Re: L11-D067 Approved for Preliminary Plat - DRB # 1008926 (and Final)

# HYDROLOGY DEVELOPMENT SECTION DEVELOPMENT REVIEW BOARD MEMO

Re: Francisco Lopez, Bridge/Eucariz Grading & Drainage Plan (L-11/D067)

Lot 316A, Unit 3, Town of Atrisco Grant Engineer's Stamp dated 09-21-12

Drawing file: FINAL / L11-D067 approved GandD 8-15-12 stamp.pdf

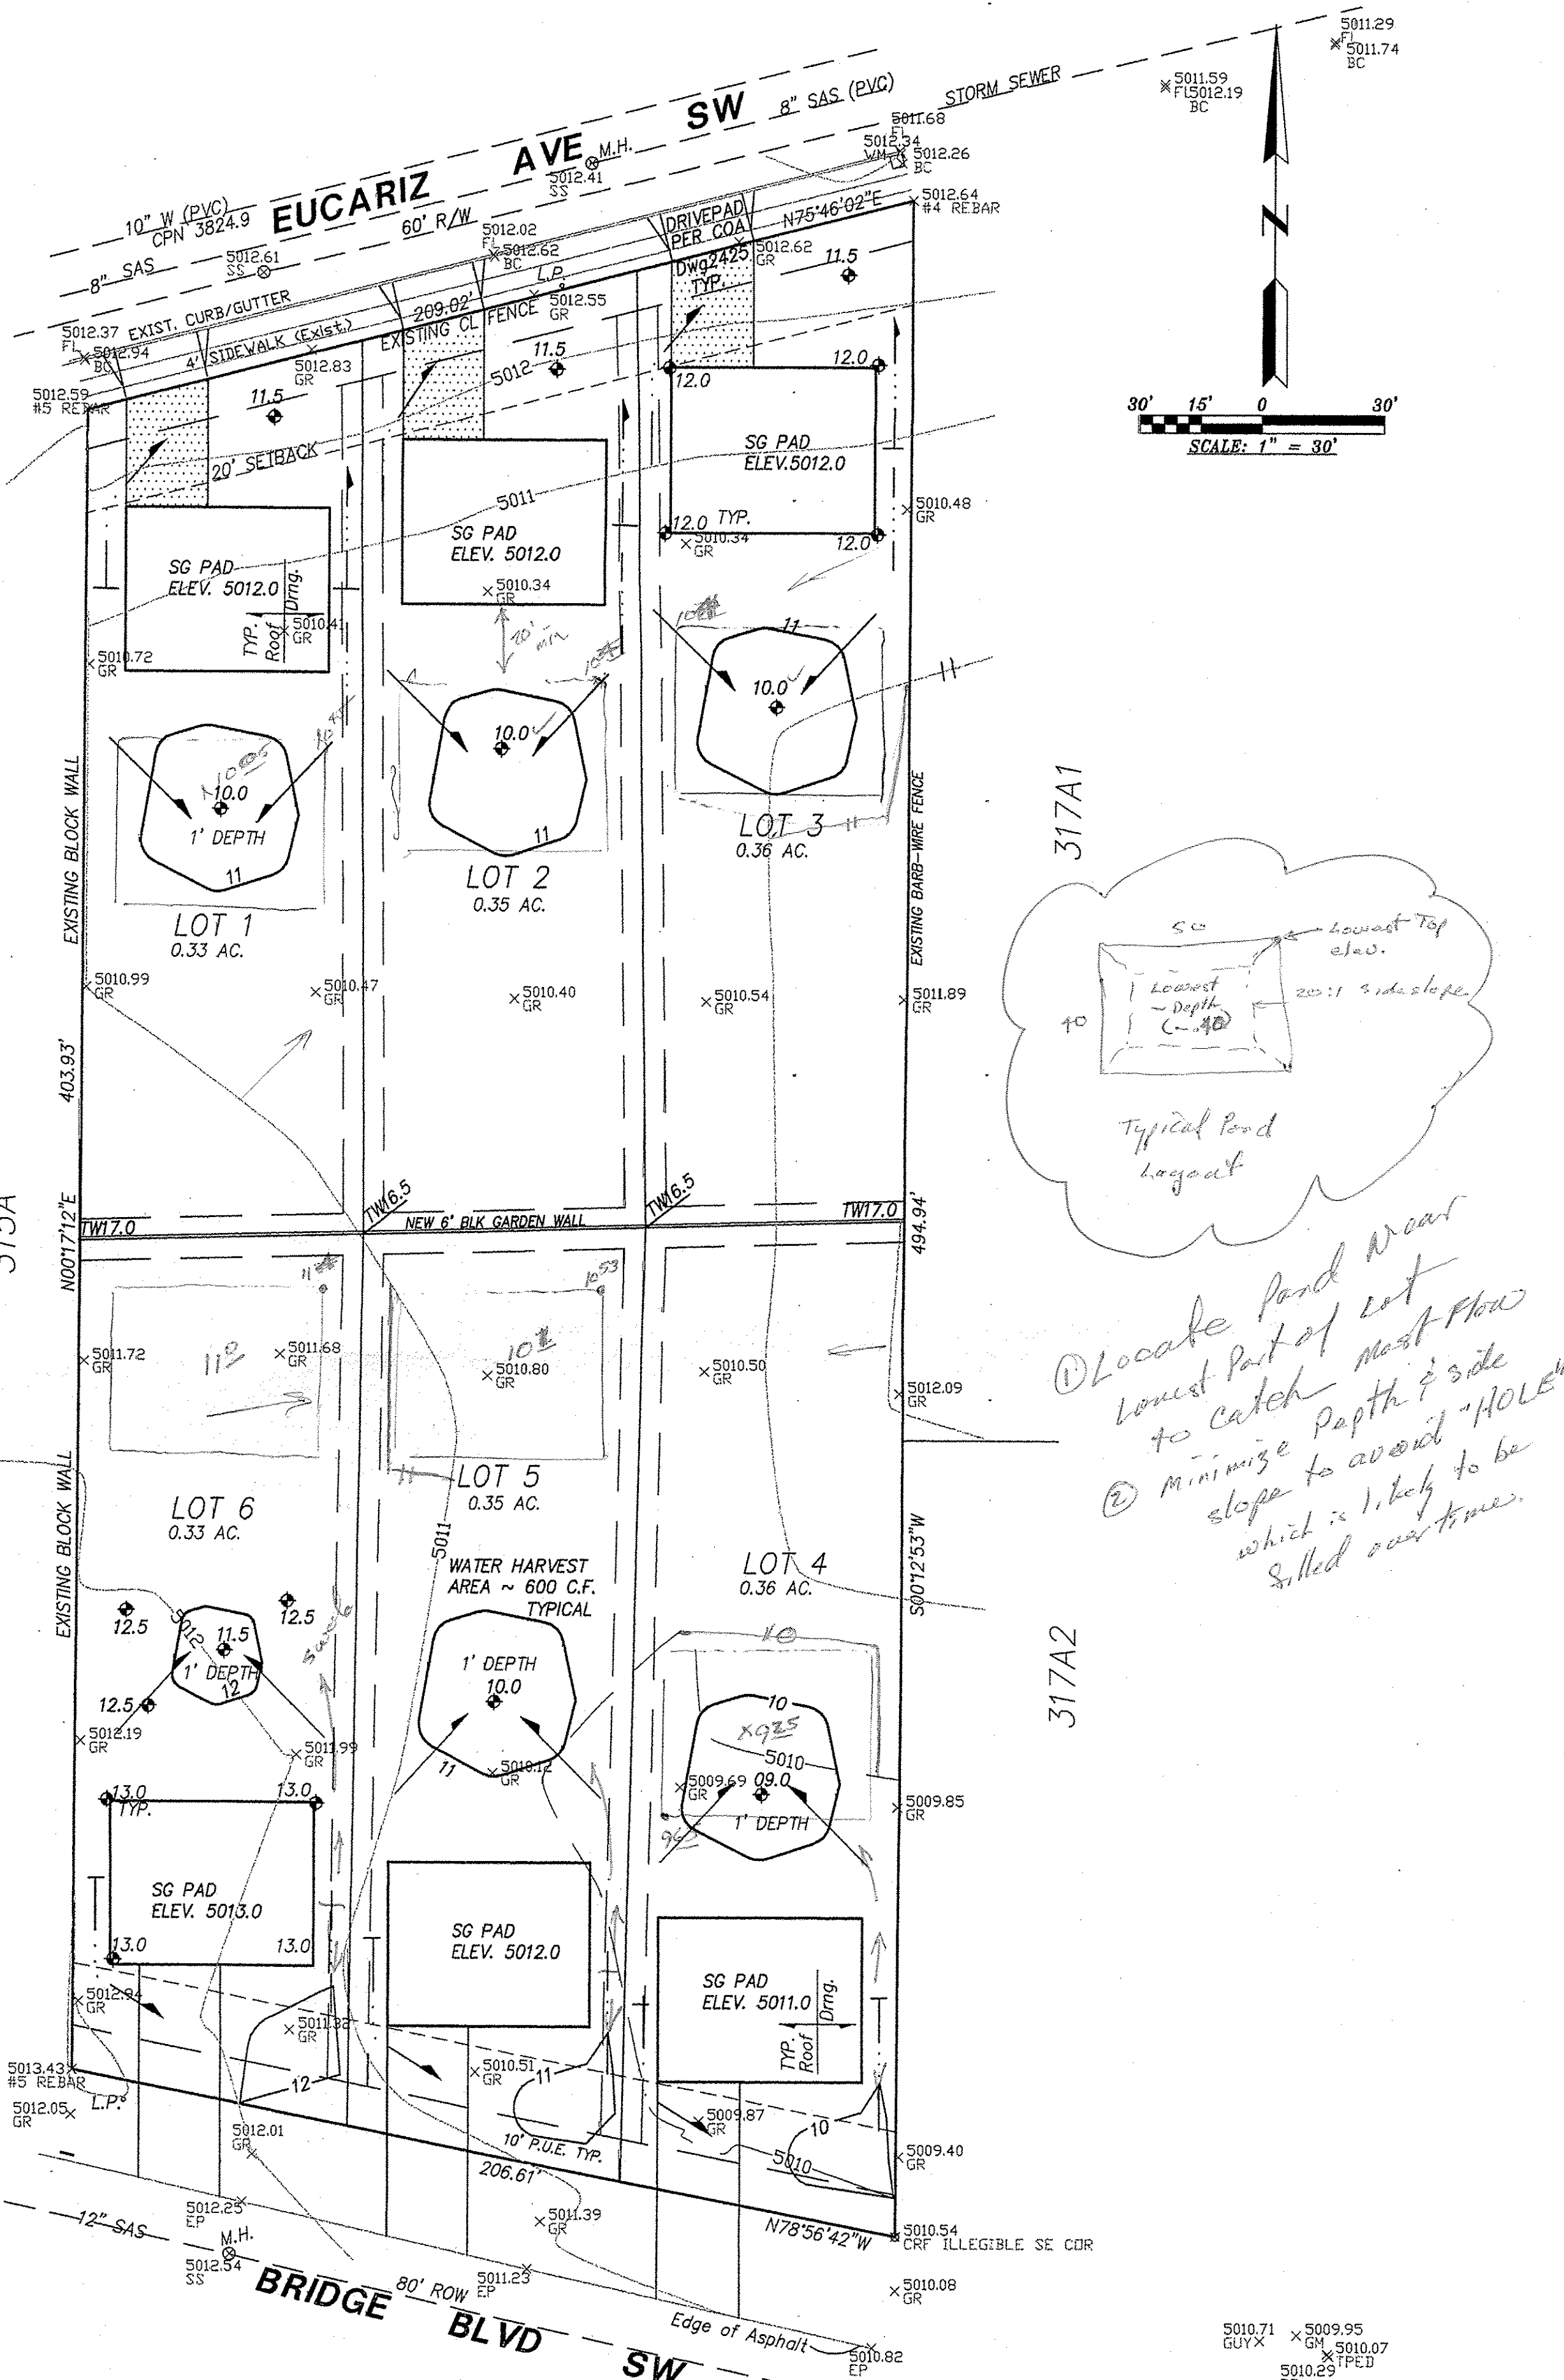
Final Plat and Grading Permit approvals will require the grade revisions on the north lot lines. Building Permit(s) will require certification of the grading, at least for any lot requesting BP. Please call or email if you have any questions.

Prior to Final Plat approval or Grading Permit, as you proposed in a subsequent email, the spot elevations on the north lot line for Lots 1 & 2 should be raised to match their respective top of curb elevation to ensure an adequate water block.

Based upon the information provided in your submittal dated 08-15-12, the above referenced plan cannot be approved for Preliminary Plat Approval until the following comments have been addressed:

1. Discharge from this site is only allowed to be "FREE" if discharging to the street. Cross lot runoff must be limited to historic rates.

2. Run off and pond volume calculations must be included on the plan or in an accompanying table or report. Clearly label values used or estimated.

- 3. The small, 1' deep, backyard ponds are not acceptable, as they tend to get filled in over time, after the properties are occupied. Larger, shallower ponding areas should be shown, and located at the lowest area of each lot to allow all runoff to reach the pond. The whole-foot contours shown for the proposed ponds do not clearly show the pond size/limits of grading. Show a "water surface contour" to clarify the pond limits on your plan.
- 4. The front yard ponds along Eucariz need to be clarified, showing limits with "water surface contour" and overflow course.
- 5. The driveways from the northern lots to Eucariz are shown to drain to the NE, however spot elevations at R/W and on the pad indicate slope back toward the building pad. Clarify with spot elevations and swale arrows how this flow is routed.

- 6. Provide spot elevations and flow arrows on proposed swales indicating the direction of all flows to ponds and exiting the site.
- 7. Provide spot elevations around the four corners of the house pads on all lots to clarify drainage. Show how revised grades on this site match existing grades at the eastern property line, and where flows cross that boundary.

@ the ROW - I raised two spots on Lots 1/2 to 12.95 and 12.75 respectively, on my original. Good catch, thx Phil

- 1. Concur -plse see verbiage revised in latter part of text-report regarding retention / "first 1/2-inch". Cross-lot drainage is minimized/eliminated. Additionally, garden Wall is added to east bdry.

- 2. Revised rear harvesting area calcs typical calced two ways two shapes.
- 3. Shallowed up ponds to 8 inch depth. Request to do so will help balance earth work. Reduced sideslopes to 15:1. Shifted two-ponds(5/6) per Gregs suggestion. Added water surface contours. Added overall new contours, spot elevations, etc.

- 4. Deleted entirely the front 'ponds' /depressed landscaping along Eucariz. All of this runoff will be conveyed positively to the rear harvesting areas. Sized for the first 1/2" storm.

- 5. Driveway concern is alleviated because of 4 above, and new spots, swales + transverse flow direction revised on drivepad itself.
- 6. Comply added spots etc directing to harvesting areas / exiting the site.

- 7. Spots added to all four corners of pad
- 8. Concur plse see 1 7 above.
